From: Farhad Khatibi
Sent: 07 September 2023 12:32
To: Planning ContactCentre
Subject: RE: Attached letter from Kirklees Council regarding application number 2023/91280 at location Bromley Farm Quarry, Barnsley Road, Upper Cumberworth, Huddersfield, HD8 8PD

Bridges & Structures Manager
Structures Section
Highways and Streetscene
Kirklees Council

Plan Title: CROSS SECTIONAL DETAIL FOR QUARRY WORKINGS TO HIGHWAY

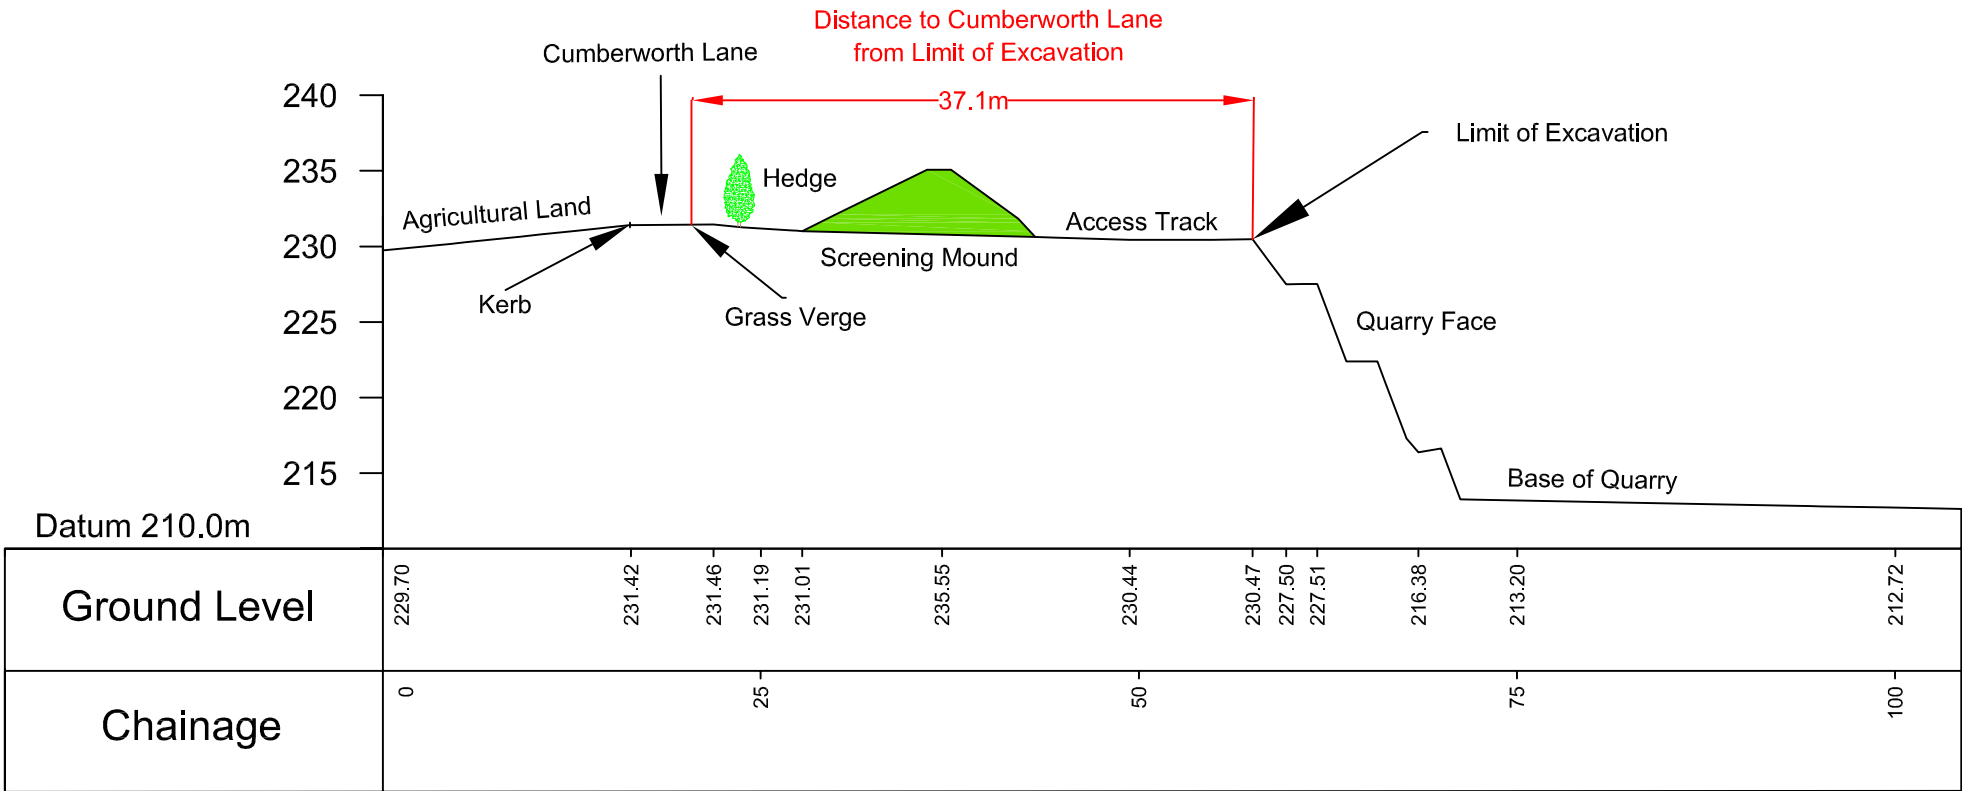
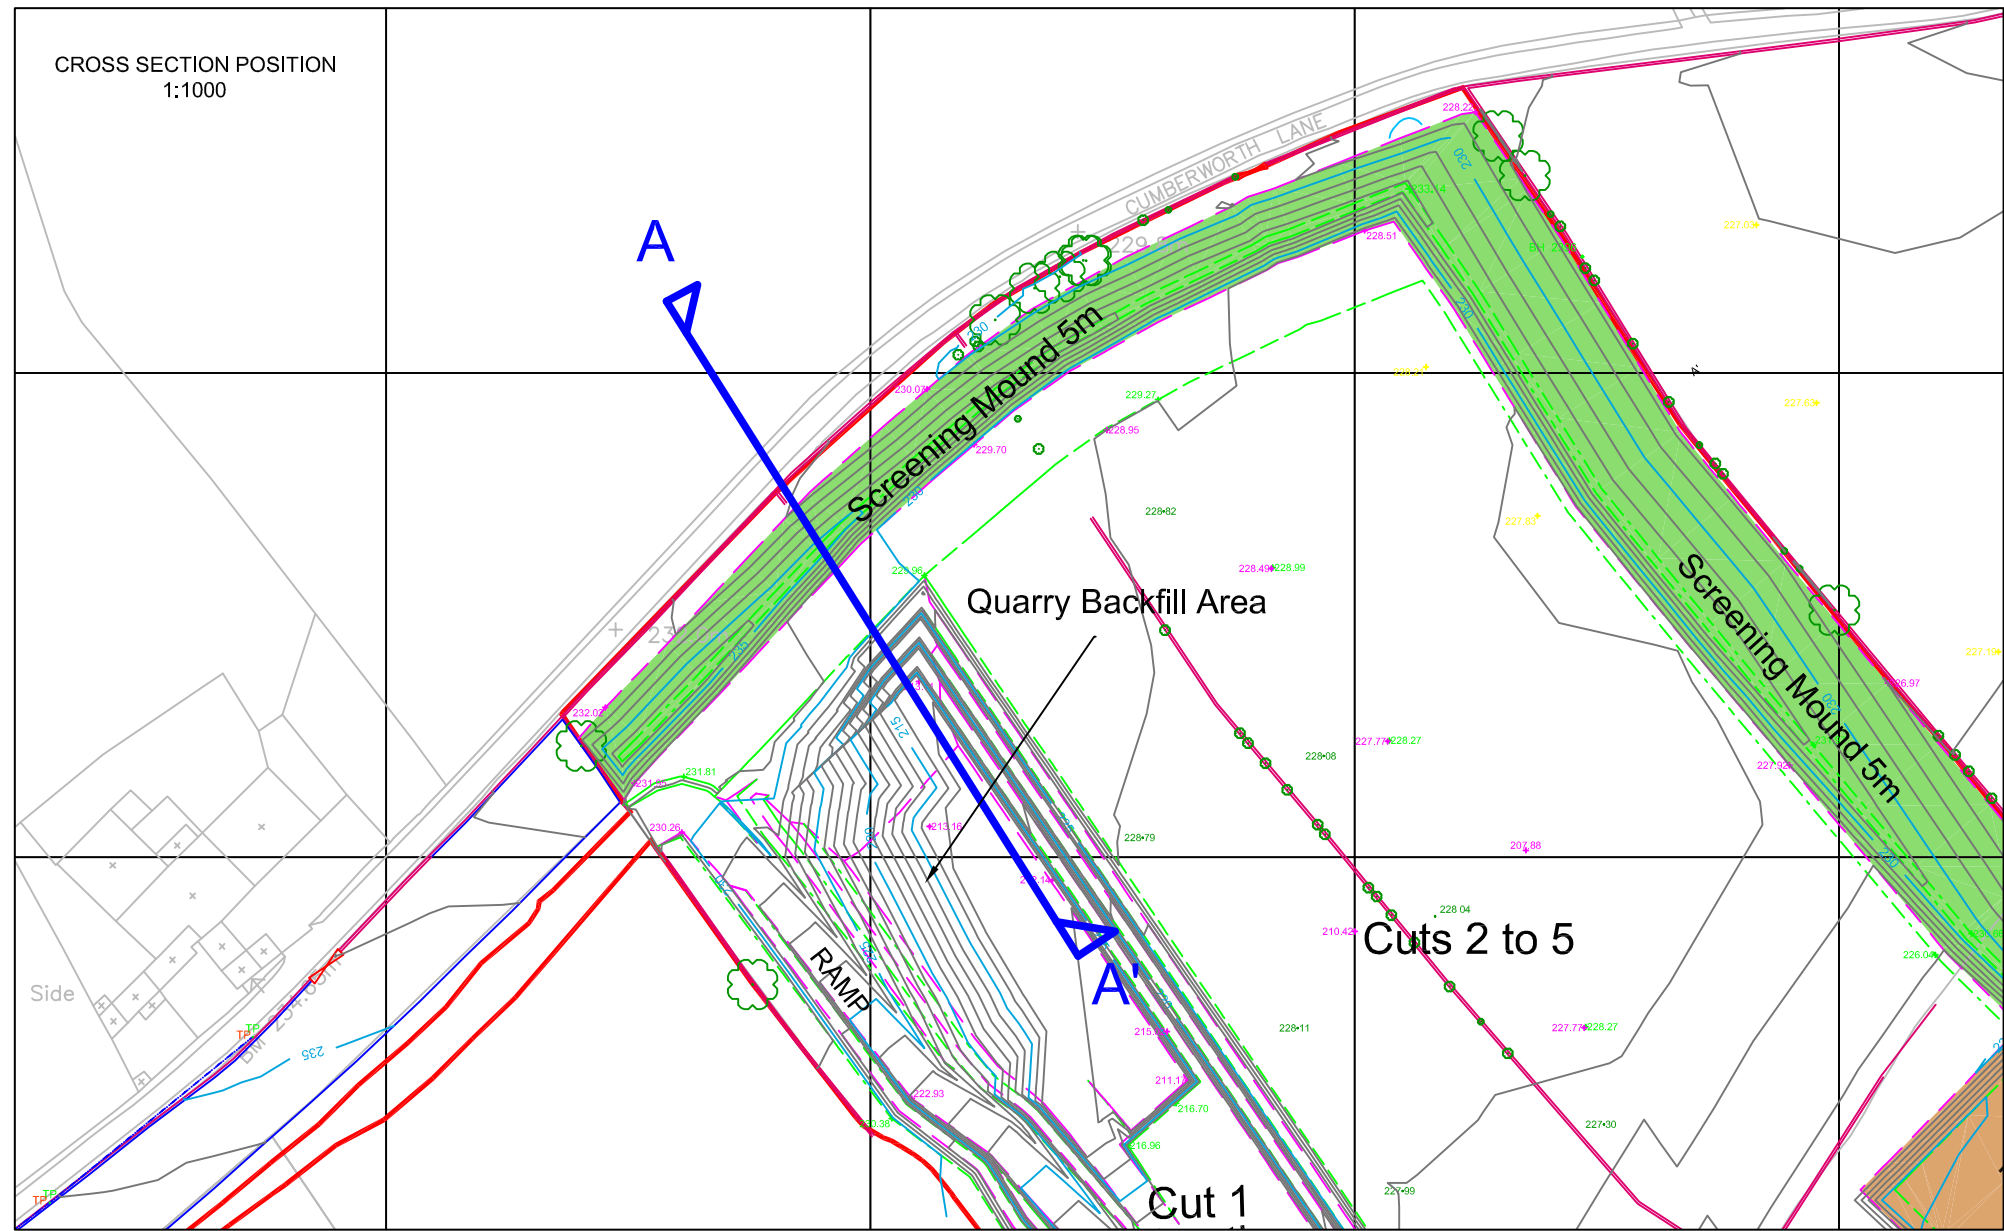
Again, this is linked to the advice I provided in my e-mails dated 7th and 10th July 2023, in that we will require suitably scaled and fully dimensioned X-sectional details across the proposed mound and extractions adjacent to Cumberworth Lane, to assess their impact on the adjoining highway and determine whether this proposal would require a formal technical approval (via submission of an AIP).
